From: Mark Warwick
Sent: 23 April 2018 16:12
To: Zac Denton
Cc: Planning.Responses
Subject: FP/14/18/T

Planning Application Ref: FP/14/18/T

Location: 6 Wellers Close, Felpham

Description of works: Crown reduction of 3m to 1No. Hazel & crown reduction of 1.5 to 1No. Hawthorn.

Ref 1

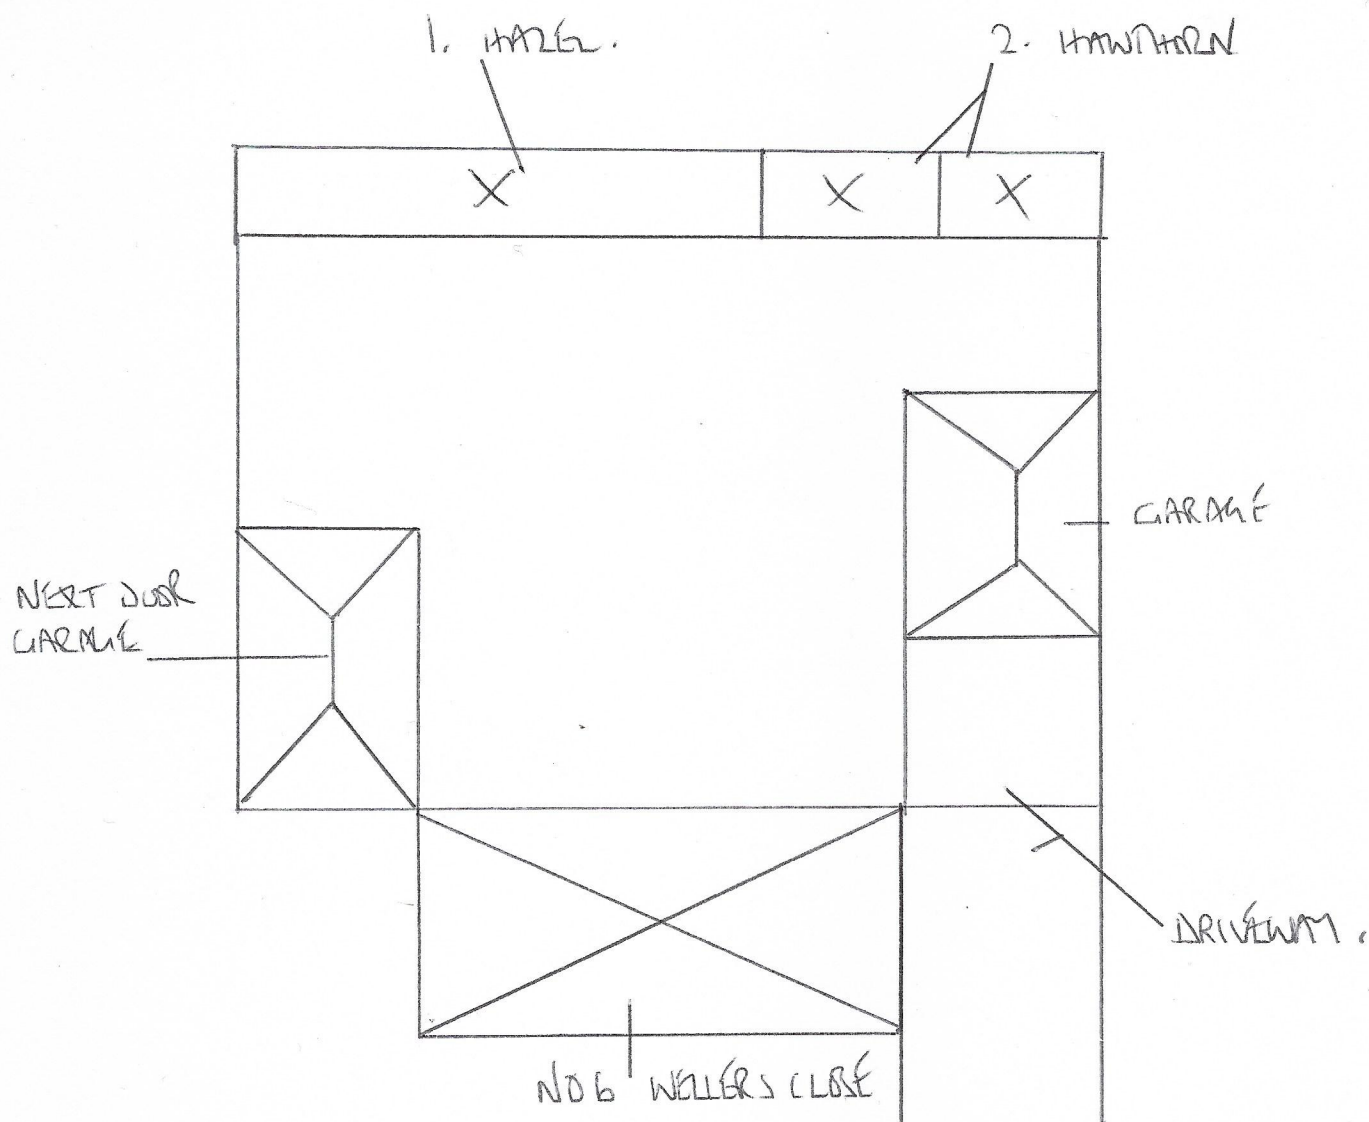
- Access was restricted to viewing only from the driveway but this is sufficient to determine the application.
- Both trees are of apparent good health with moderate form. The hazel is multi-stemmed coppice and the hawthorn is of broadly standard form – both are key constituent parts of established hedgerow which helps define the border of adjacent golf course.
- They are clearly visible from the golf course and although indistinct, add value by virtue of their contribution to group cohesion and native status rather than being of individual merit.
- They are visible from only one neighbouring residential property and only with difficulty from the property frontage.

- The proposed work seeks to substantially reduce the height and spread of both trees, which exceeds that as necessary to simply achieve the removal of property overhang. This would involve working beyond the applicant's property boundary - such work will require the permission of the adjacent land/tree-owner.
- The trees should continue to make a small but worthwhile visual and ecological contribution to the immediate locality while remaining viable for long-term retention despite the intense management they are likely to receive.

- I recommend **CONSENT** for this application, subject to the following conditions:

- Where whole branches are to be removed and final cuts made close to the trunk or branch union they are to be made as shown in Figure 2 of BS3998:2010
- Where branches are to be shortened back the final cuts are to be made at the correct angle shown in BS3998:2010 and adjacent to a live bud or lateral.
